From: Arun District Council Greenspace

Application ref: LU/149/20/PL

Description: Installation of a 4m high timber sculpture shaped in the form of 3 No. waves, fixed to a concrete base. This application is not CIL Liable (Zero Rated).

Location: Littlehampton Wave Sea Road Littlehampton BN16 2NA

Drawing Title:
Plan & Elevation of Sculpture
Concrete Plinth

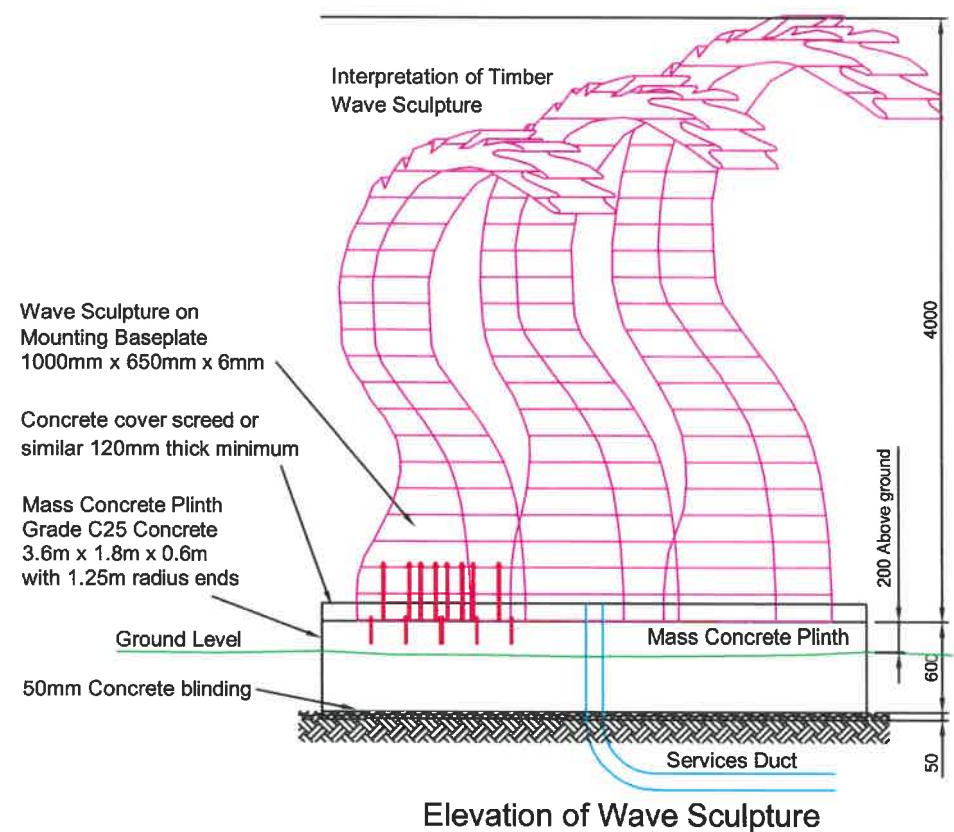
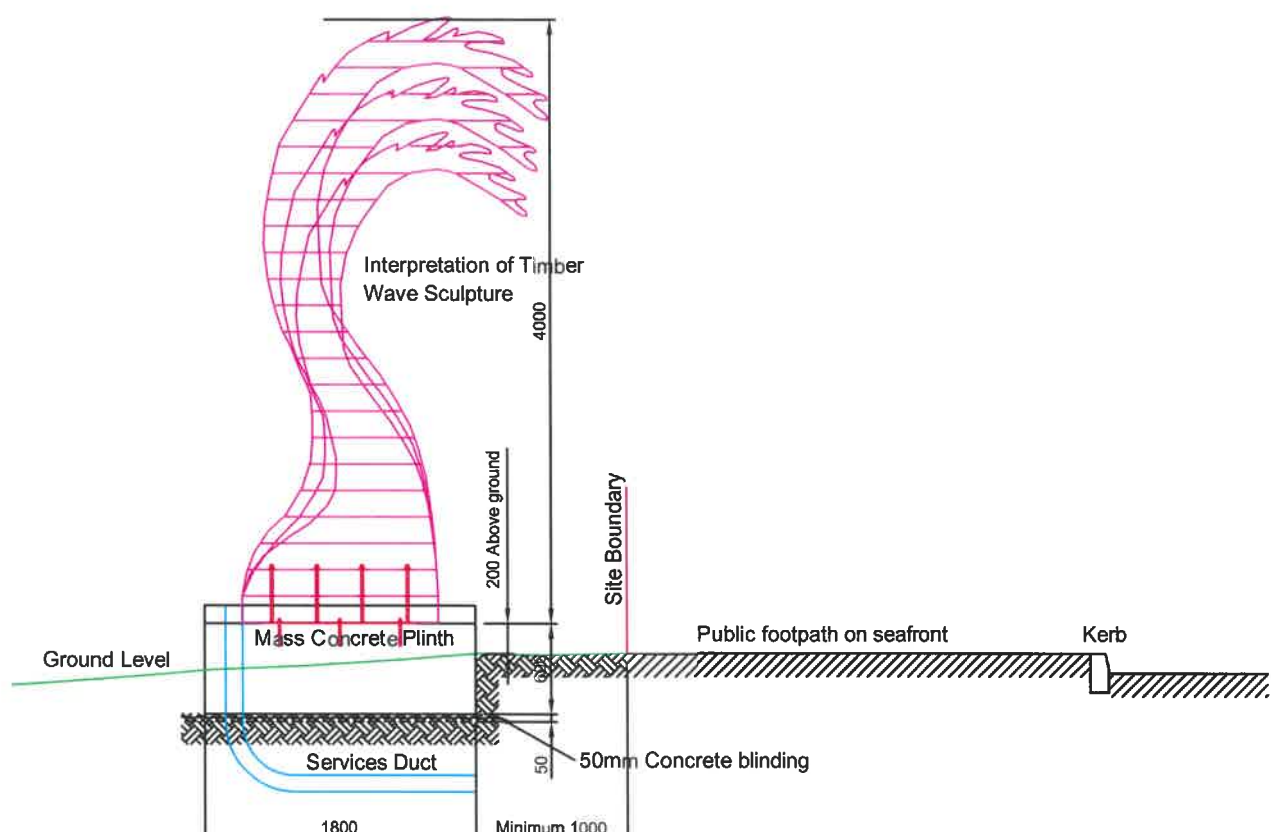
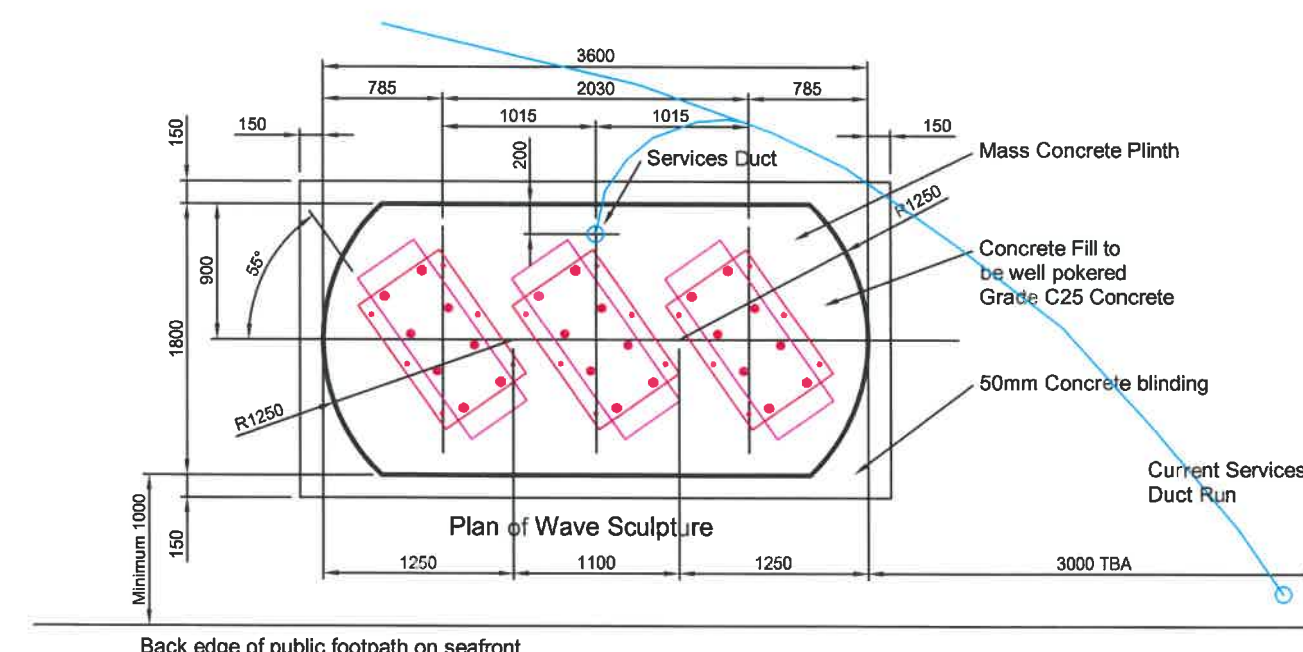
There would be no perceived detrimental impact of the proposals in this location, providing public art, a good visual link and use in wayfinding. The slab base work will be blended into the existing landscape with additional extension grass species planting to the existing scheme.

Further landscape provision of grasses and coast tolerant species to mirror the existing scheme to be incorporated in the immediate surrounds of the slab base work. No further landscape mitigation required.

I would recommend support of the proposals, subject to the incorporation of the base work mitigation planting above.
